Notice of Exhibition of application for Marist Catholic College North Shore (SSD-10473) (North Sydney) *Correction of the previous public exhibition notification – 264 and 270 Miller Street, 34 – 36 and 40 Ridge Street North Sydney

As delegate of the Heritage Council of NSW, the following comments are provided:

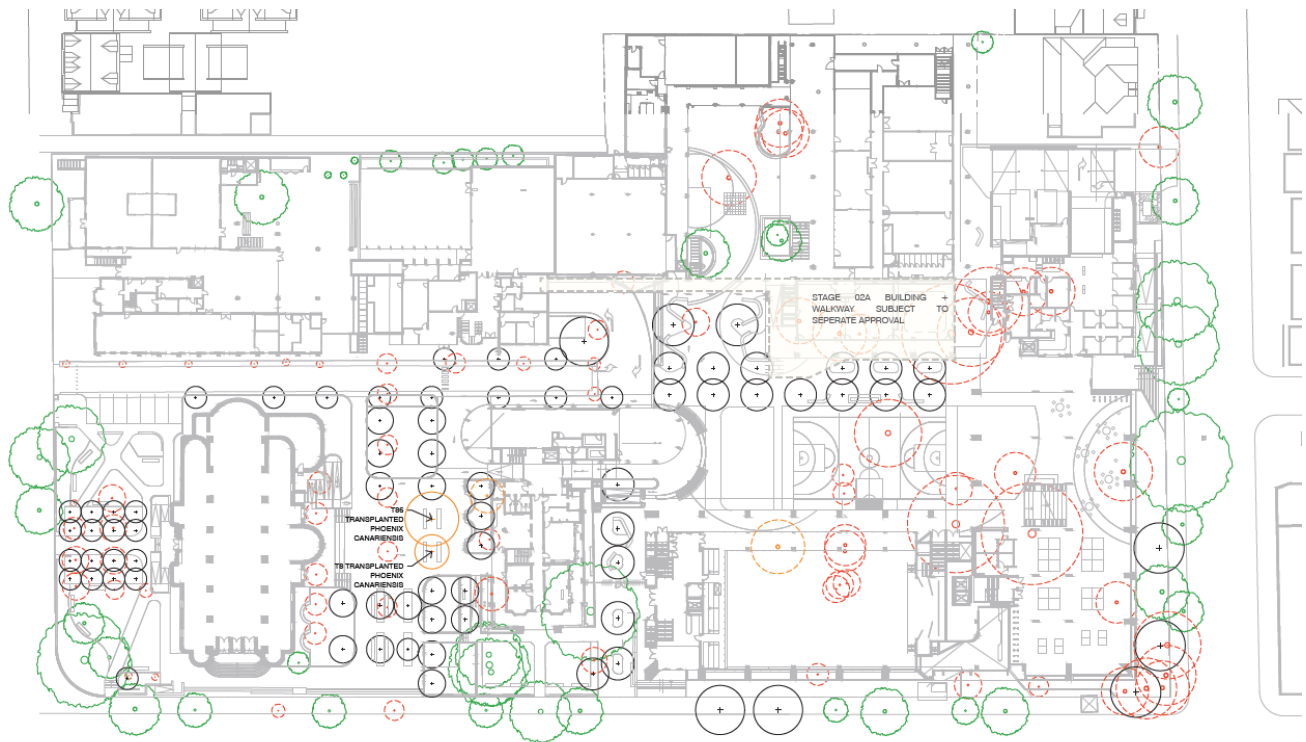
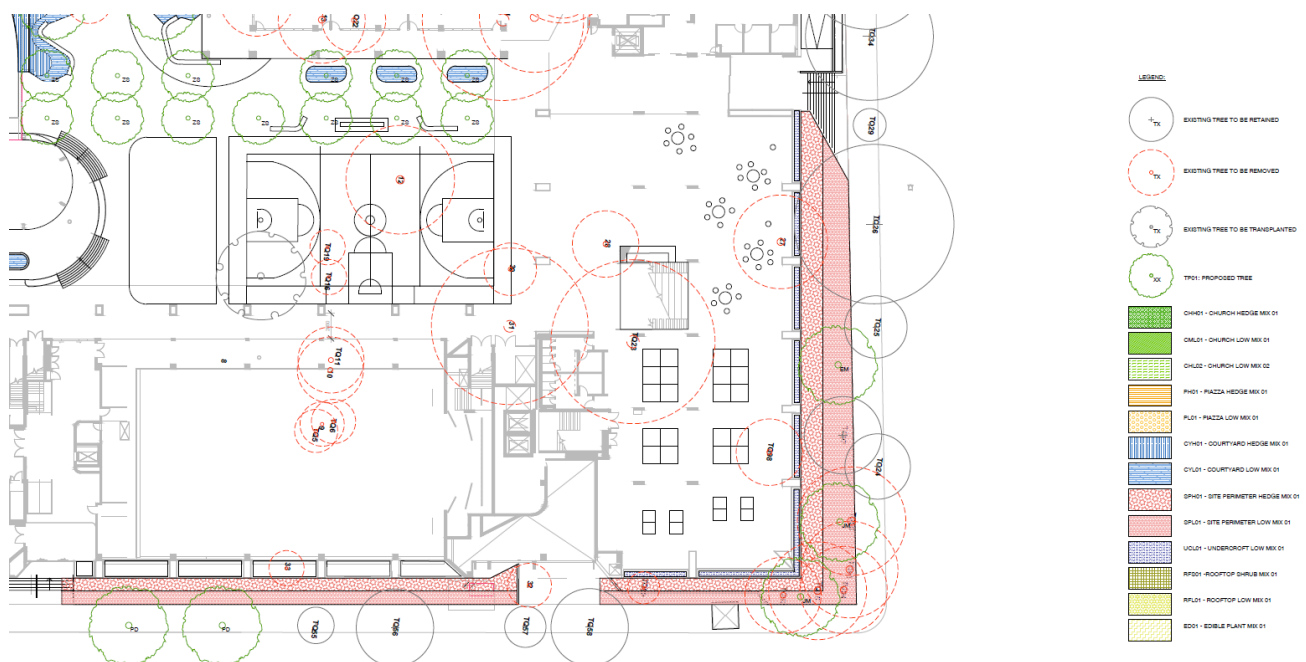
3. The Visual Impact Analysis states that ‘views of the proposal may be visible from within the north-west quadrant of St Leonards Park, in particular the formed pedestrian path that traverses the park in a north-east to south-west direction (VIA, p10). The proposed Curlow Building at the corner of Miller and Curlow Street requires the removal of green space that supports a group of high and moderate significance trees, including a mature *Jacaranda mimosifolia* (Jacaranda) (Tree TQ96) 14 metres in height. This corner is located directly opposite the key entry point to the park and the view along the axial path running east west through the park (CMP, p44). The narrow setbacks to Miller Street associated with the proposed building and the proposal to offset with roof plantings, fails to preserve existing vegetation or allow for suitable deep rooted landscaping such as trees that would sufficiently mitigate the bulk and scale of the proposed development and preserve the landscape character of the locality (Figure 12 and 13, VIA, p21 and 22).

Artists Impression at Corner Miller and Carlow Streets

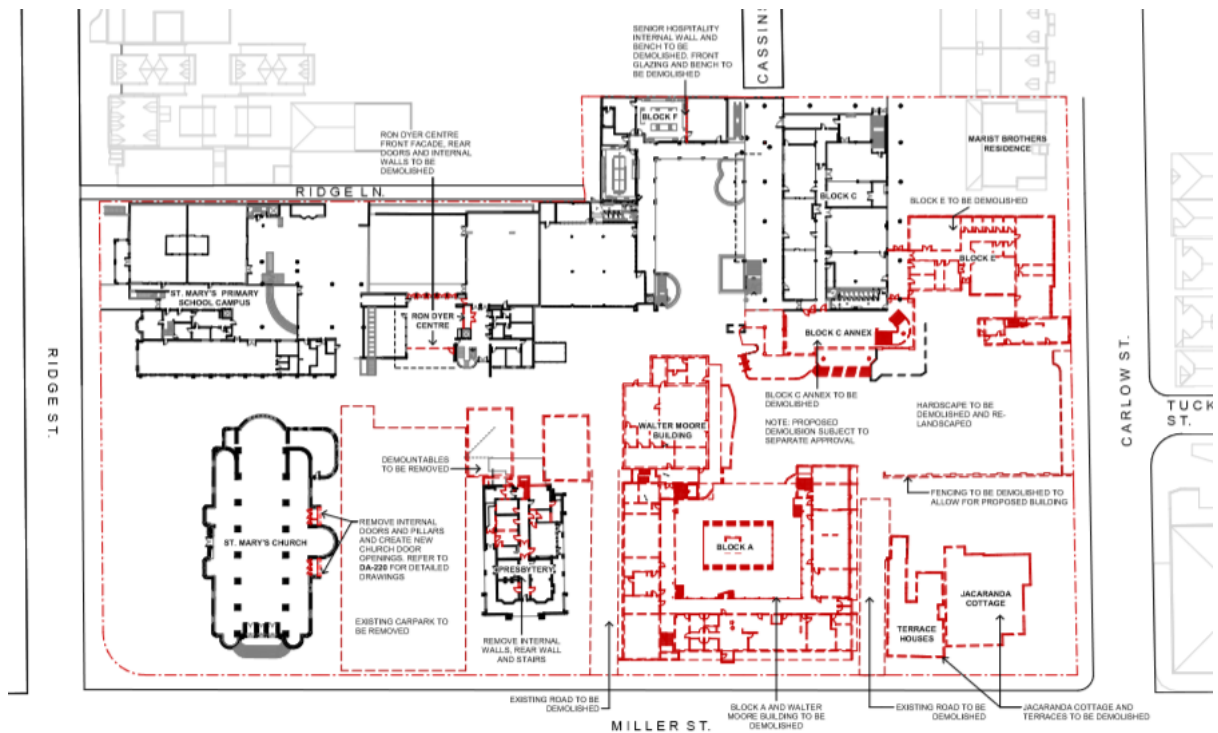
5. Based on the above, the building setbacks and loss of green space at the corner of Miller and Curlow Street is considered unsympathetic to the existing heritage values of the locality and streetscape and it will adversely impact views to and from St Leonards Park.
